Tel: 01903 737756
Email: planning@arun.gov.uk
www.arun.gov.uk/planning
Please ask for: Mrs D Johnson
Email: daun.johnson@arun.gov.uk
Telephone: 01903 737762
Our Ref: R/1/26/L
Your Ref:
Date: 12th January 2026

Listed Building Consent for Alterations, Extension or Demolition of a Listed Building

Development: Listed building consent for the demolition and reconstruction of the western elevation of the laundry building.
Location: Land To The North Of Rustington Convalescent Home Sea Road Rustington BN16 2LZ

Location Plan

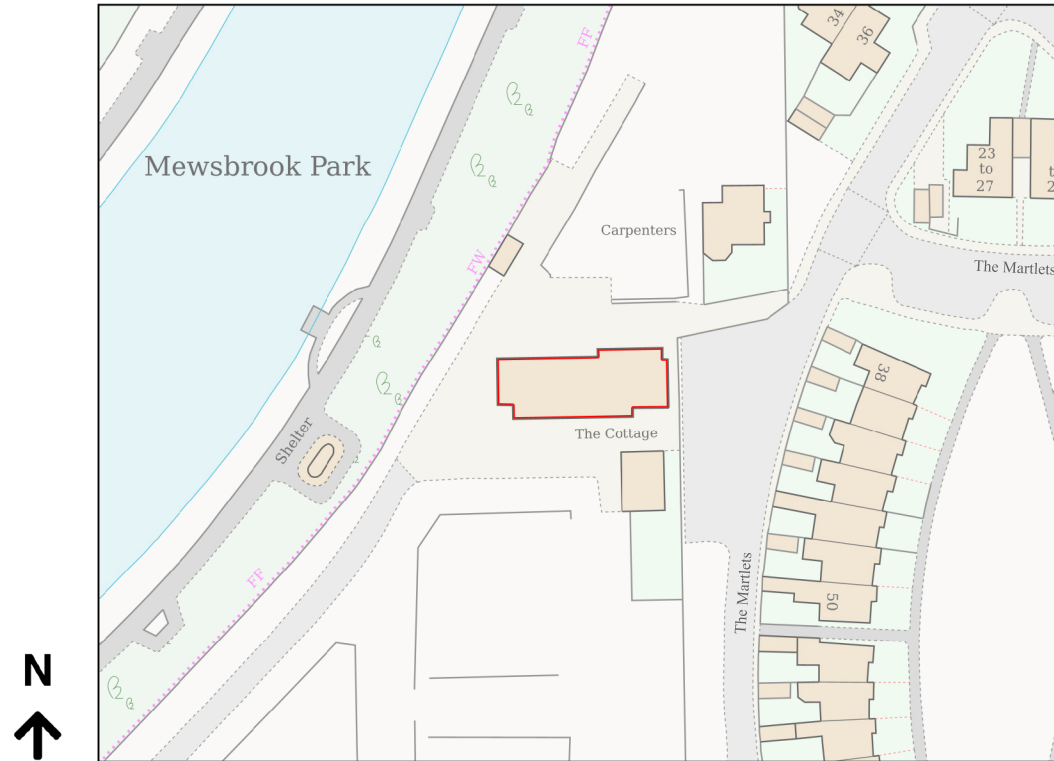
Location Plan

Please provide one named road.
